**From:** Linda Griffiths  
**Sent:** 04 February 2020 11:24  
**To:** DC Support  
**Subject:** FW: 19/00895/REM Wykham lane Bodicote

**From:** Judith Ward <Judith.Ward@Cherwell-DC.gov.uk>  
**Sent:** 13 January 2020 09:58  
**To:** Linda Griffiths <Linda.Griffiths@Cherwell-DC.gov.uk>  
**Subject:** 19/00895/REM Wykham lane Bodicote

Drawing file: 2832-5-2-DR-5014 P3 LANDSCAPE PROPOSALS.pdf

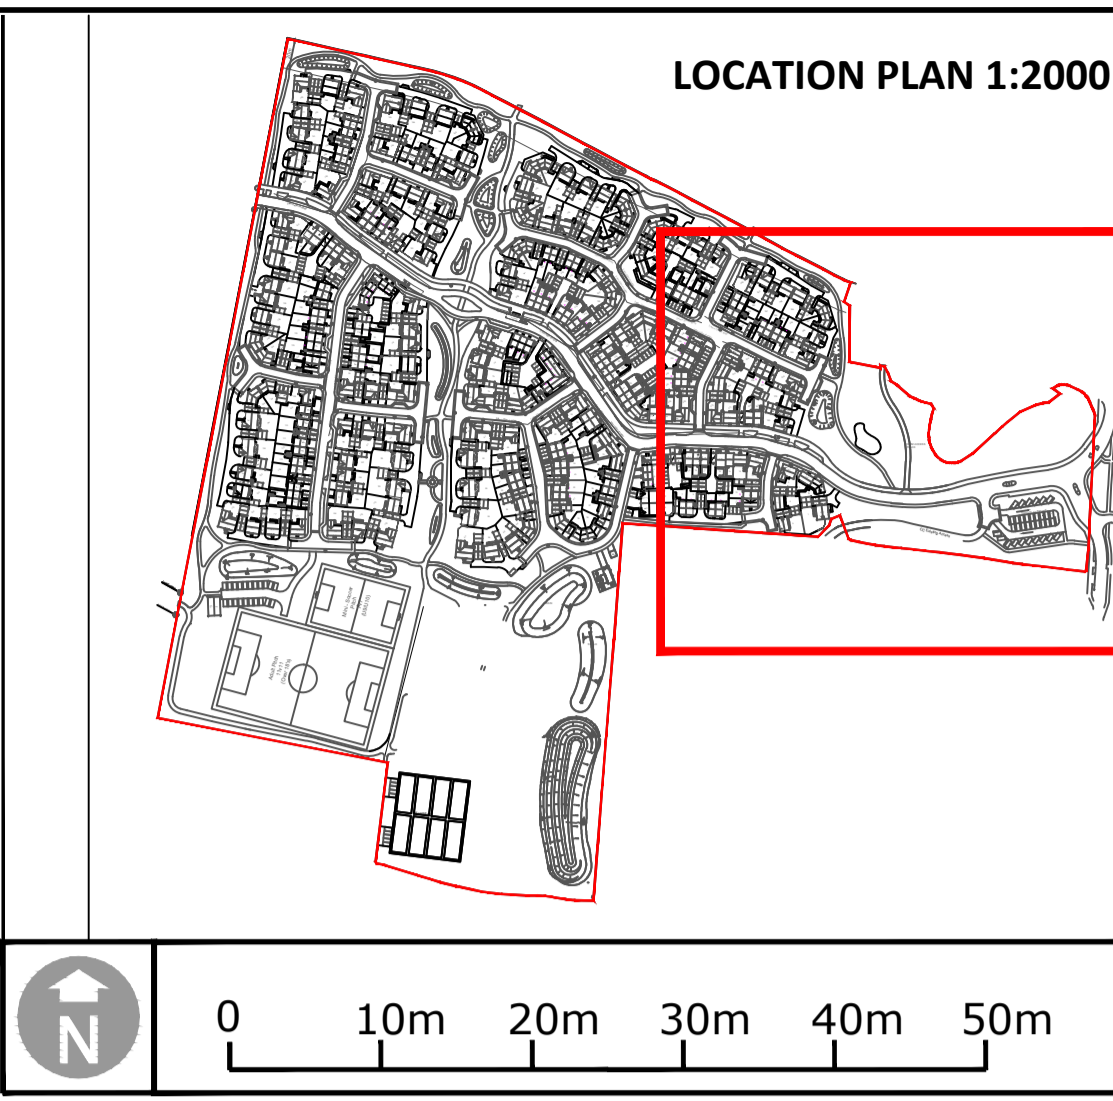
No changes have been made to the planting plans following my comments to you on 19<sup>th</sup> August.

There is no planting for texture scent and colour.
